Lancashire Archaeological
Advisory Service

Your ref: 3/2017/0319

Planning Application 3/2017/0319: Demolition of existing kitchen outrigger and replacement with new two storey extension to side and rear to include six new bedrooms on first floor. New extension to continue over existing first floor terrace. Insertion of four new rooflights to front elevation; Waddington Arms, Clitheroe Road, Waddington BB7 3HP

Proposed Elevations & Section

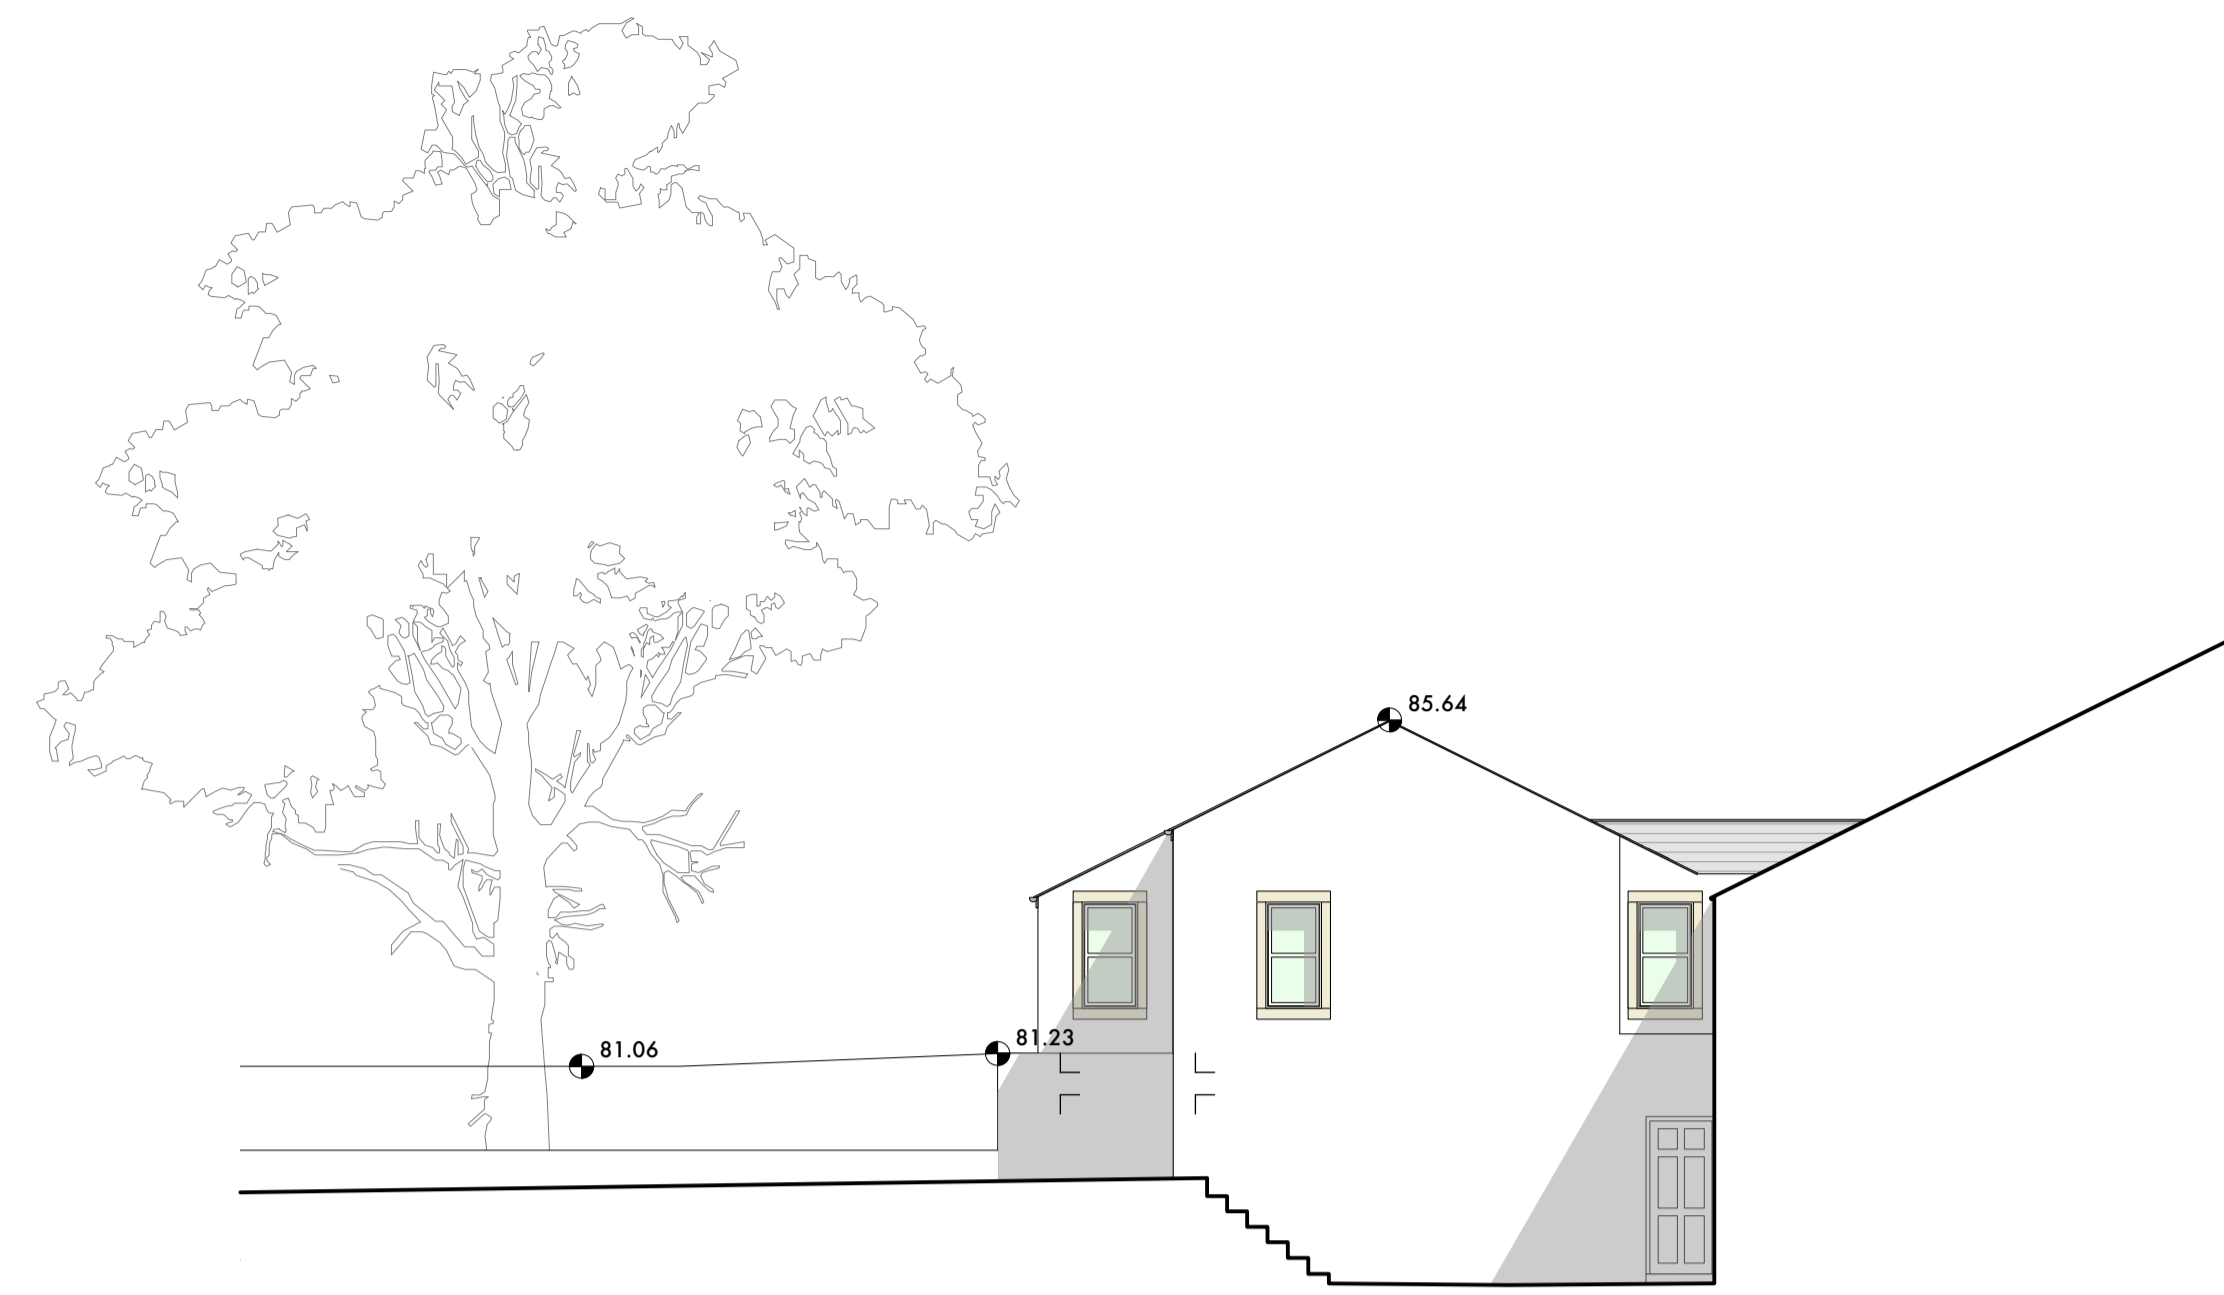
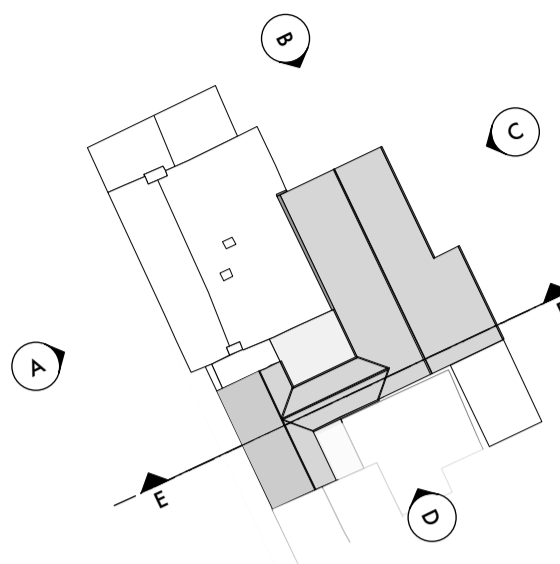
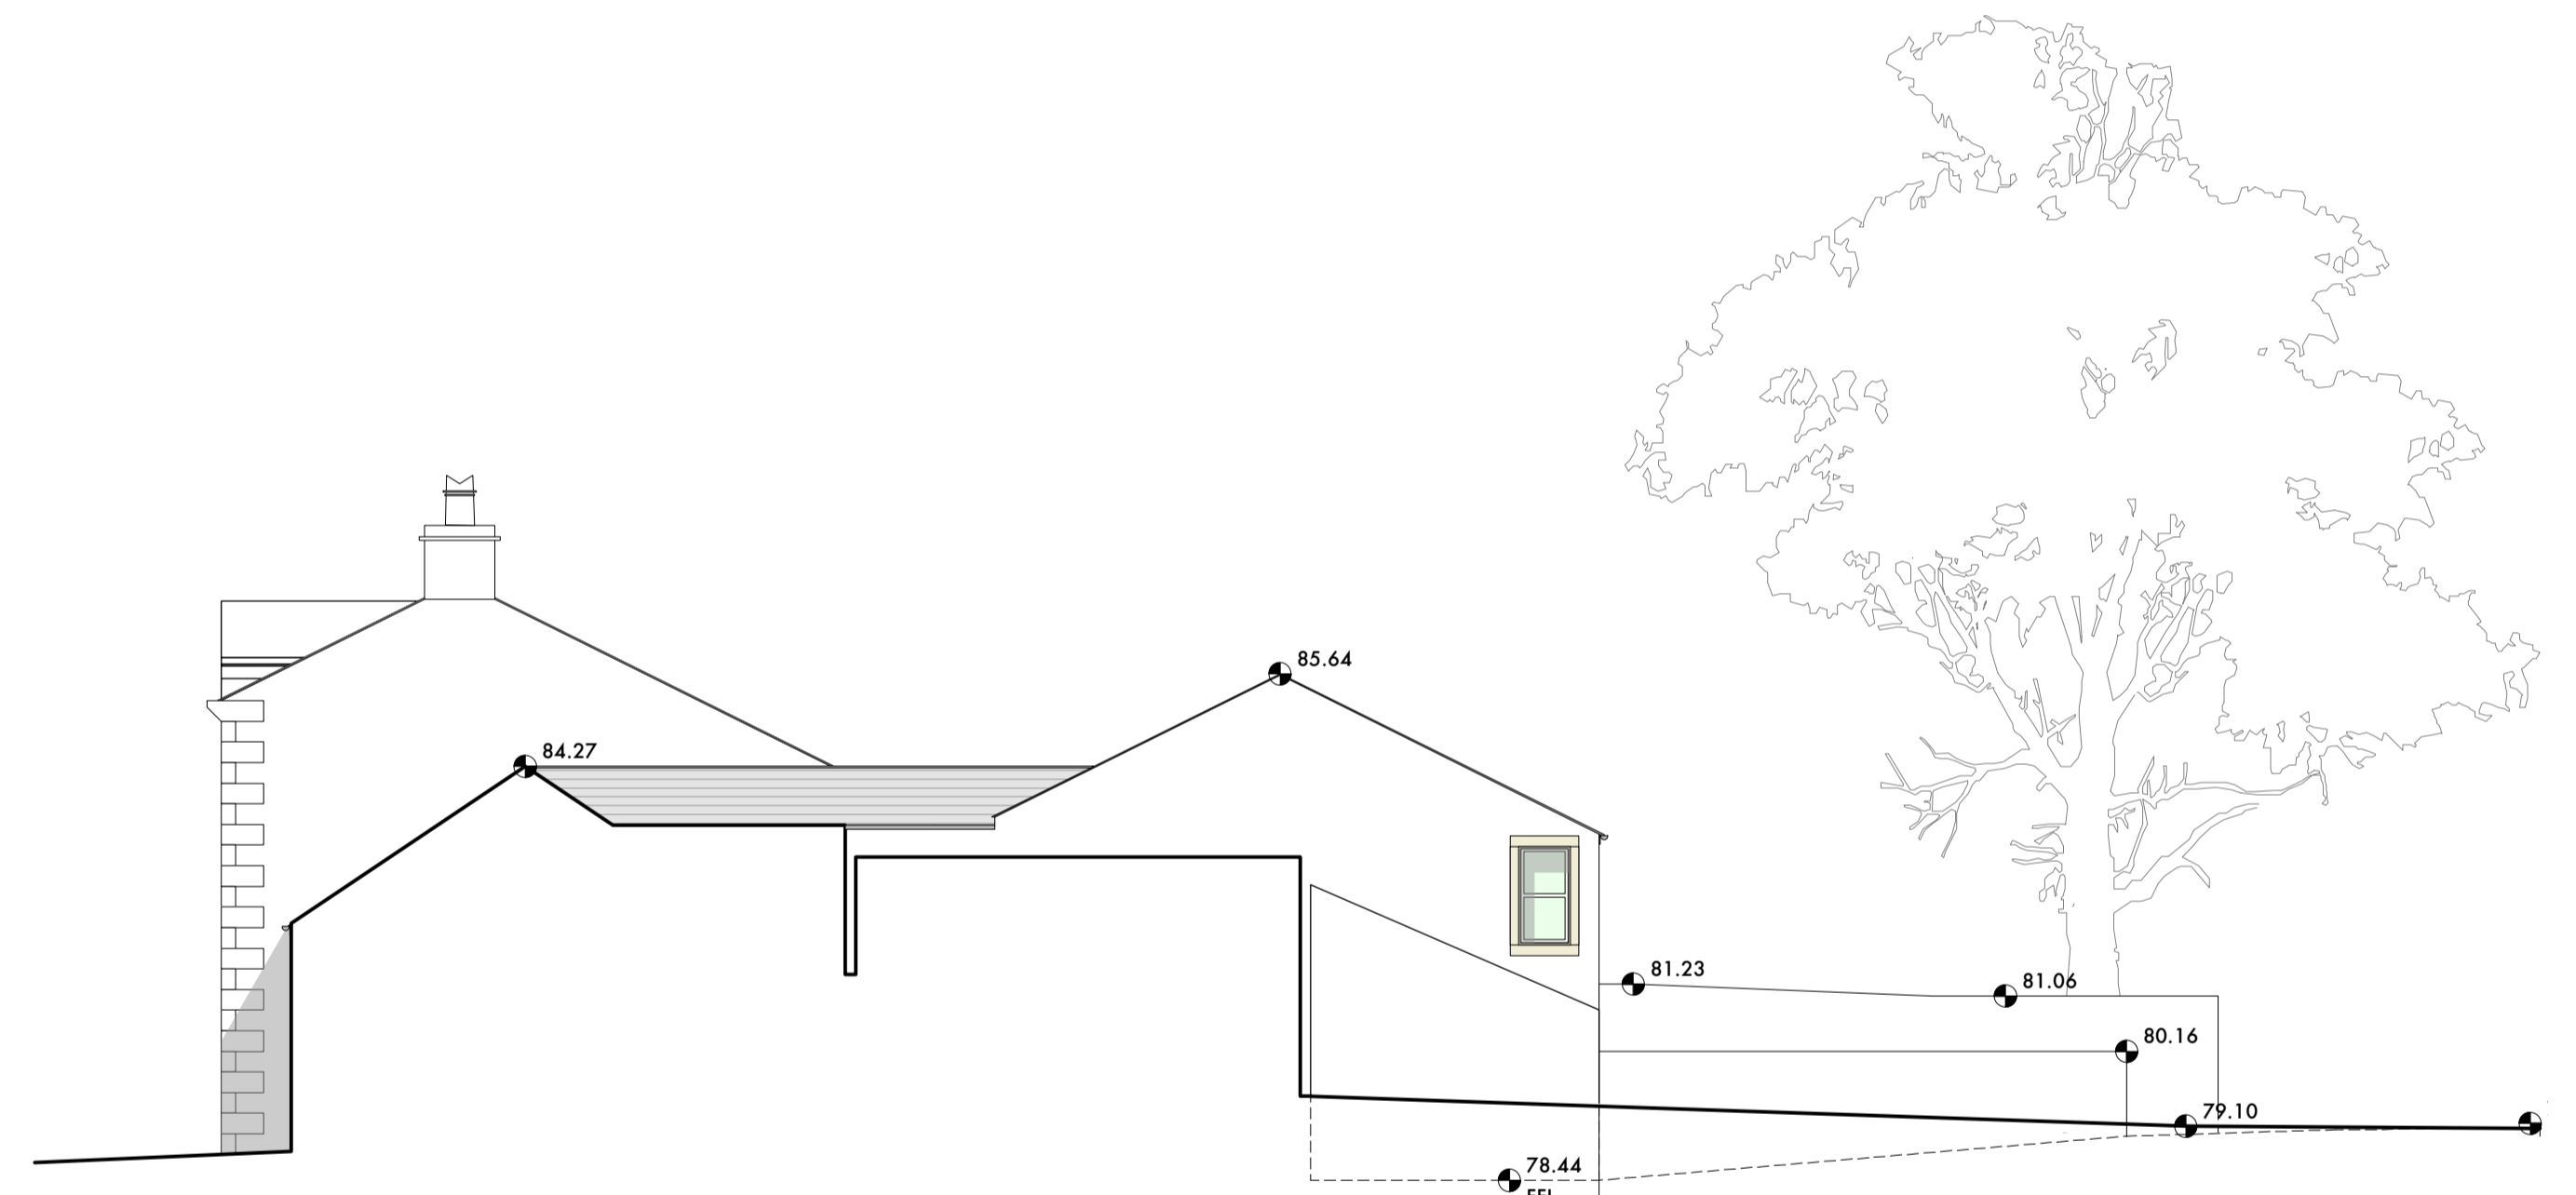
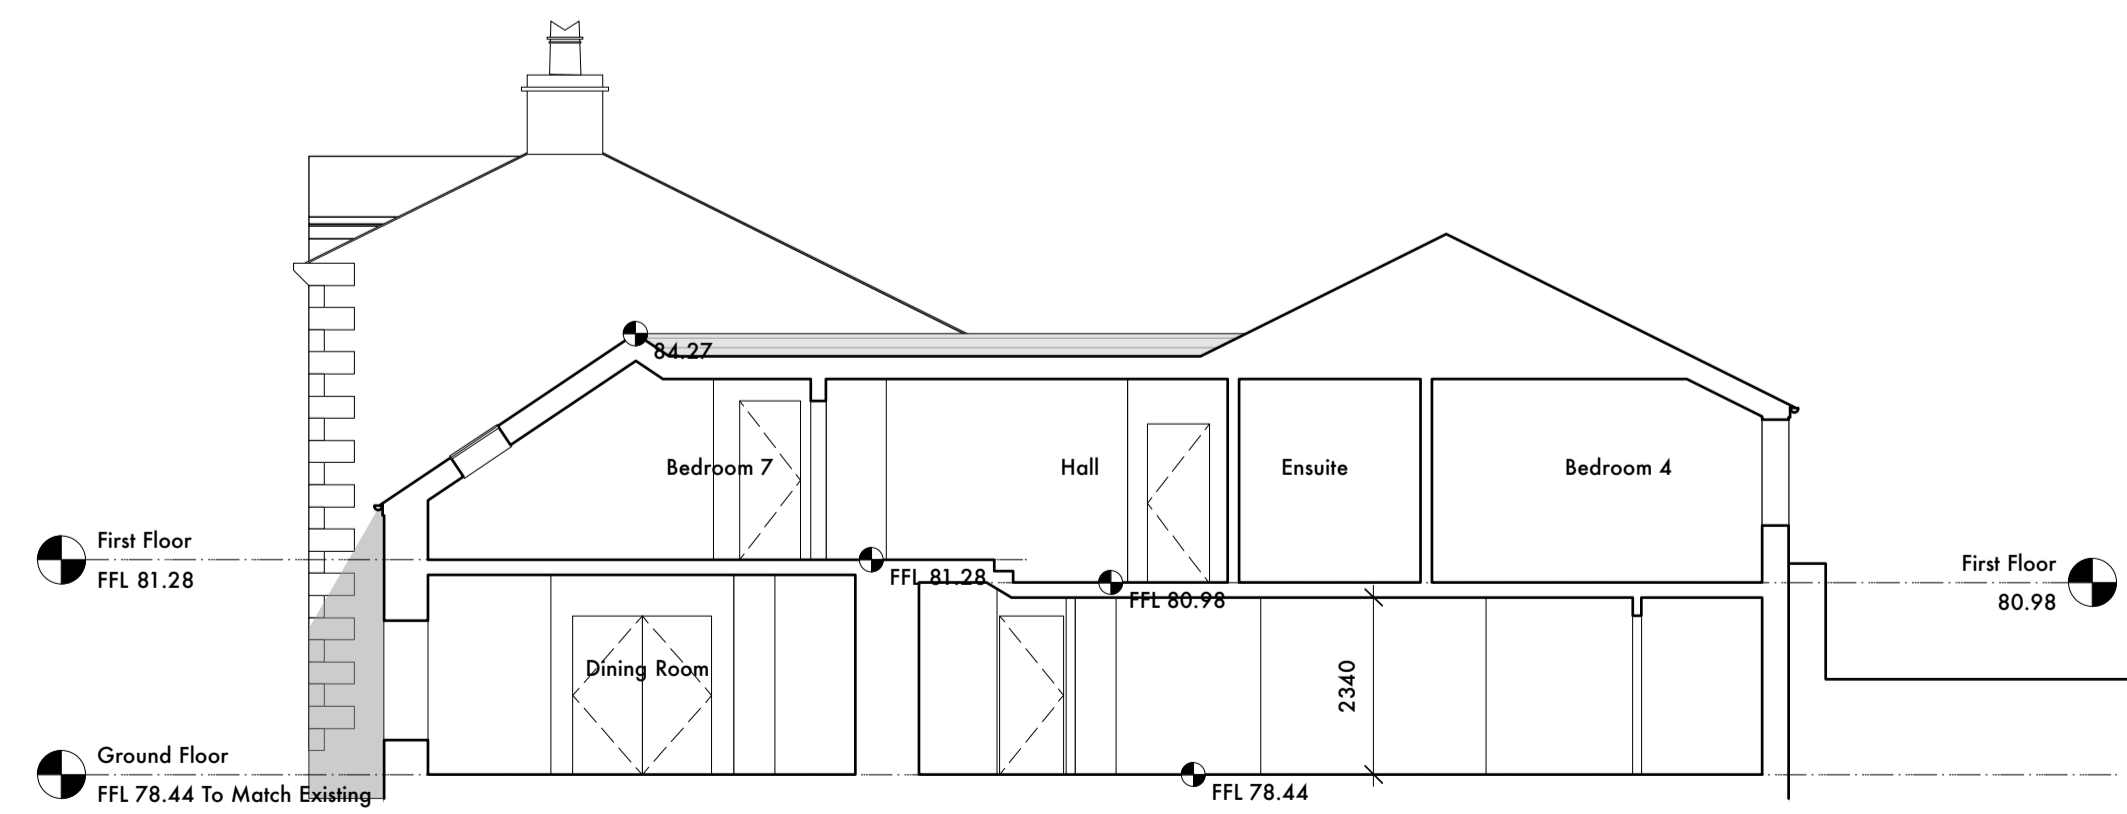
mullioned windows, apparently of 17th-18th century type, at first floor level. At least one of these windows is impacted by the proposed extension and is not shown in the drawings 'as proposed'. The significance of this alteration is not assessed.

We would recommend that the Heritage Statement is revised to include

- (i) An outline phasing of the building;
- (ii) A description and assessment of the heritage value of the rear of the building, with particular reference to those elements which are proposed to be lost, altered, built over or otherwise changed;
- (iii) An assessment of the significance of the proposed changes;
- (iv) A series of photographs and drawings of the front, rear and interior of the building to support the assessments of heritage value and significance, and to allow the impact of the proposals to be clearly understood.
